**Christina Stacey - Re: Permit #2966 - 11 Devonshire St.**

**From:** Nick Rofe <nqrofe@gmail.com>  
**To:** Christina Stacey <cstacey@portlandmaine.gov>  
**Date:** 12/31/2015 9:37 AM  
**Subject:** Re: Permit #2966 - 11 Devonshire St.

DEVONSHIRE

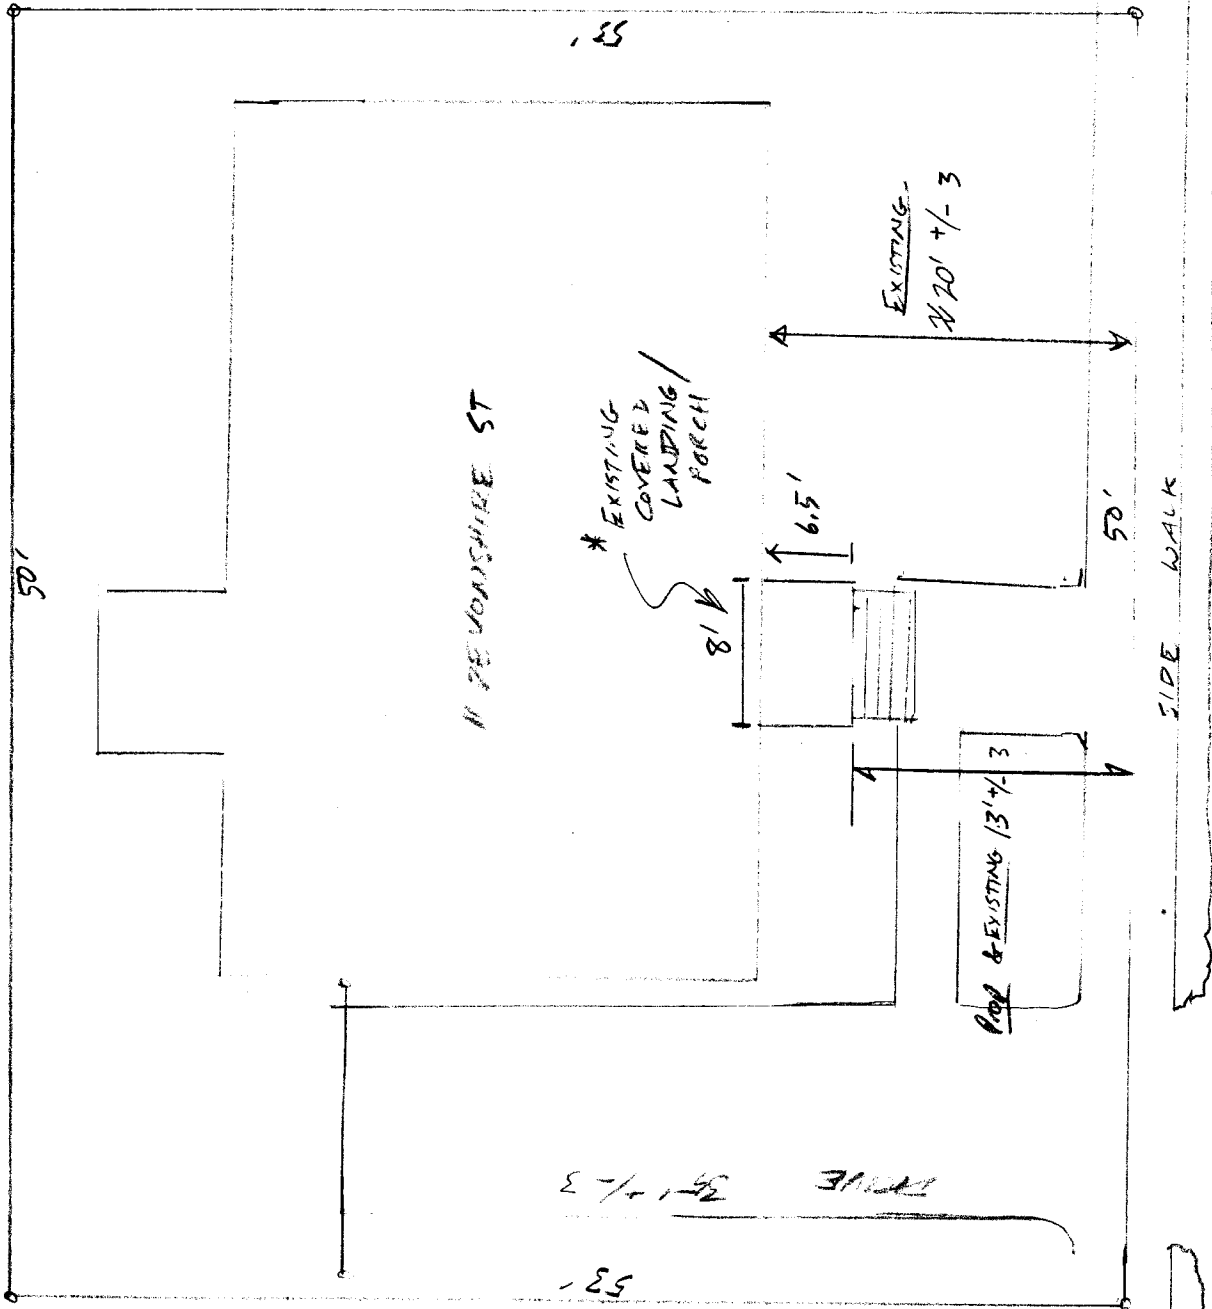
I have started reviewing this permit application but there is an issue about which I wanted to contact you. The porch to be enclosed is about 13 feet from the front property line, which is less than the normal 20' front setback required today. Since this seems to be a legally-existing non-conforming open porch, it is allowed remain. However, completely enclosing a non-conforming porch is generally not allowed except in two circumstances. One exception allows conversion to an enclosed porch if the "the major portion of the enclosure is of glass" (i.e. more than 50% of the new wall area will be glass). The other option is a provision that would allow the setback of the enclosed porch to be reduced down to the average setback of the structures on the two adjacent lots.

In order to approve the application, the project will either need to be revised to meet the 50% glass provision, or information will need to be provided about the setbacks of the principal structures on either side of this lot. Would you please let me know how the landowner wants to proceed? Don't hesitate to let me know if you have questions about this information.

I have talked with the home owner and checked out the adjoining lots. We want to try and do the second option by averaging out the adjoining setbacks to give us a reduced requirement. I'm not 100% sure where the row and lot line are, but based off the assessor info for our structure 's setbacks, I'm making an estimated measurement.

The house to the left (number 15), which is visibly closer to the road, looks about 10'. and the building to the right is at 0'. It's right on the sidewalk.

Will I need to provide a new land plot showing all three structures and lots?
